From: Kate Giddings
Sent: 23 April 2019 10:32
To: Fiona Fitzgerald; Michael Eastham
Cc: Planning.Responses
Subject: RE: BE/38/19/PL

From: Fiona Fitzgerald
Sent: 15 April 2019 11:05
To: Planning.Responses
Cc: Michael Eastham
Subject: BE/38/19/PL

TOP SOIL RELOCATION
SITE PLAN
1744-TS-P02-A
1:1250 @ A3
12.02.19
DRAWN BY

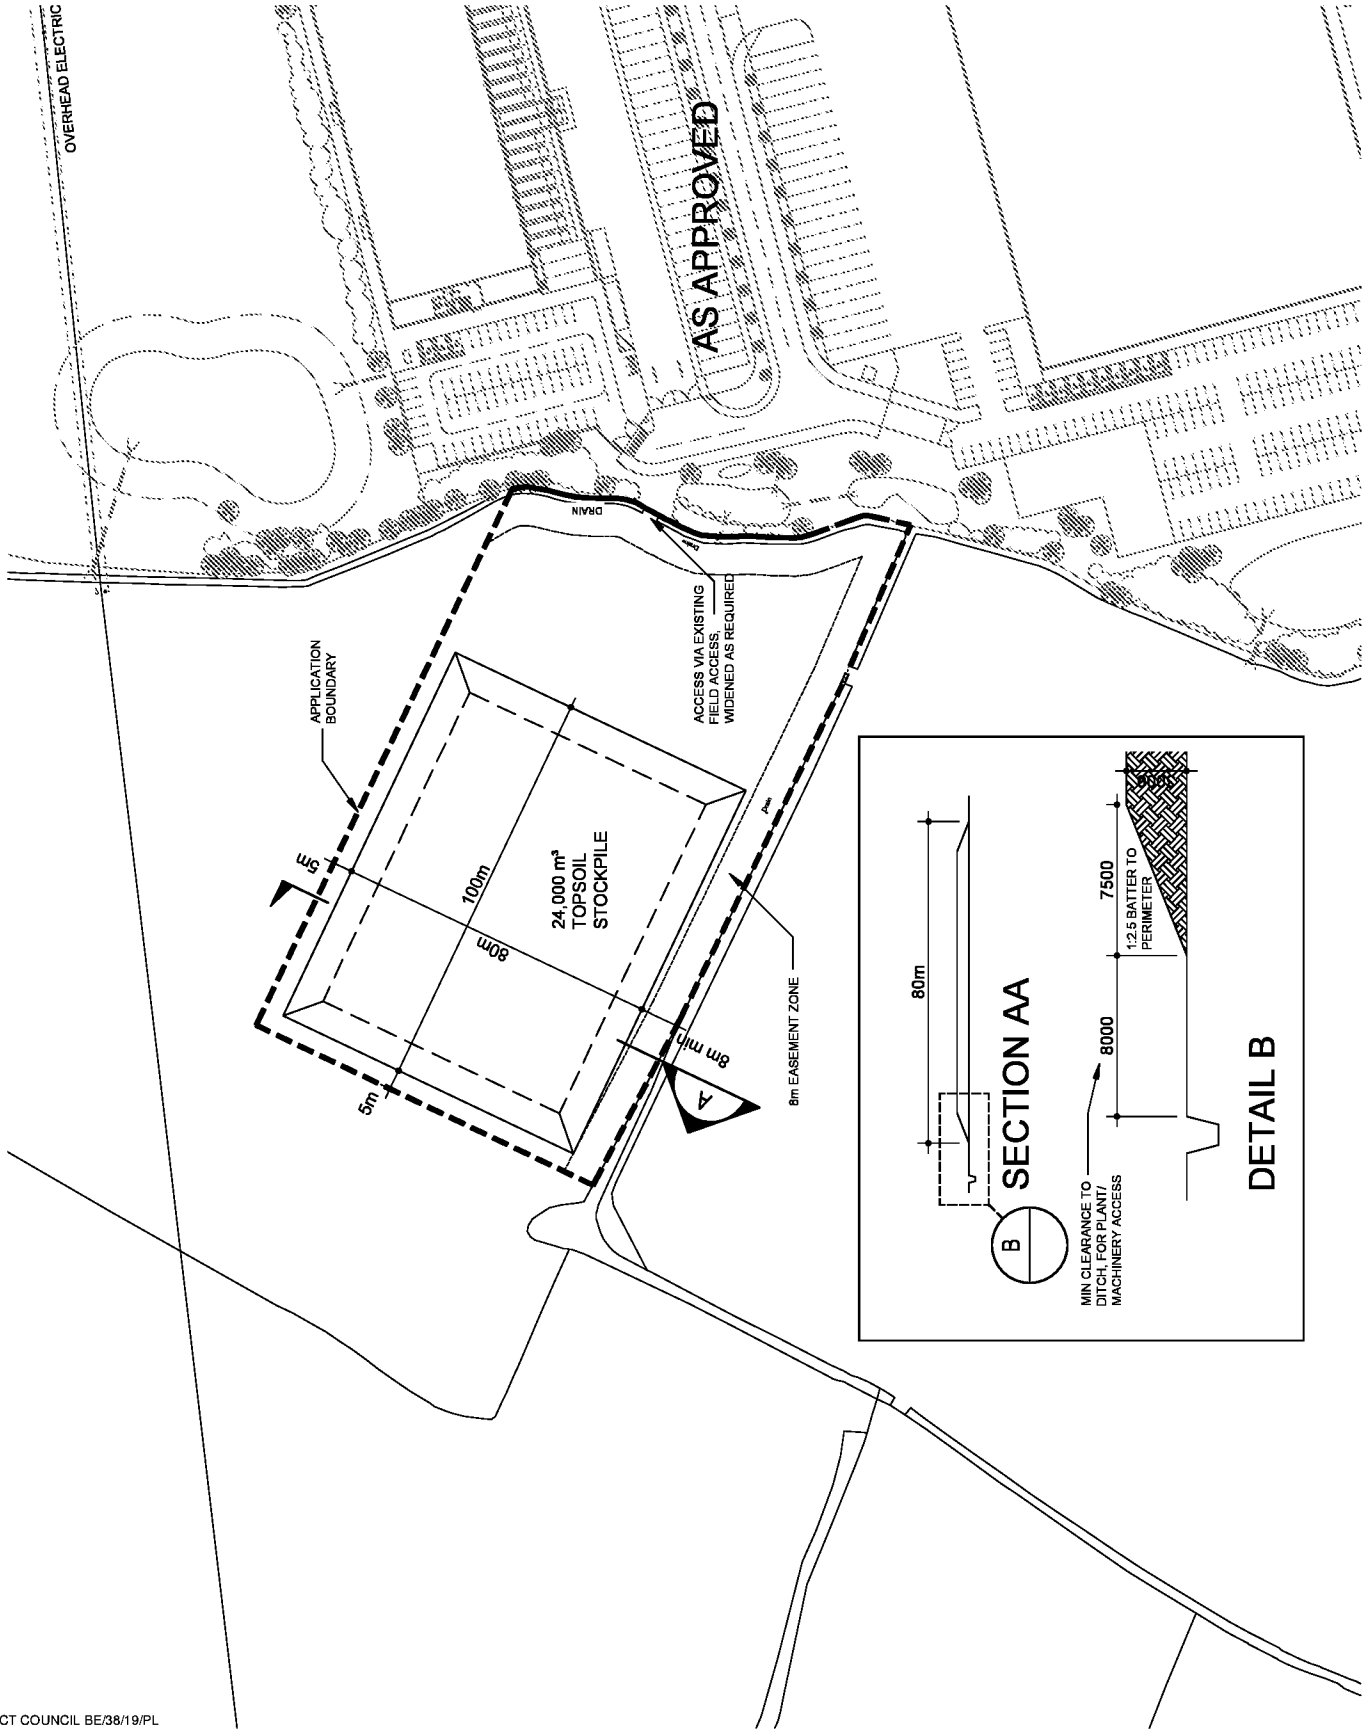
It is recommended that the bund material is kept separate from the underlying topsoil to prevent cross-contamination.

Please could the applicant advise measures that will be taken to ensure that dust from the stockpile does not affect local residents. This should include where they consider the nearest sensitive receptors to be.
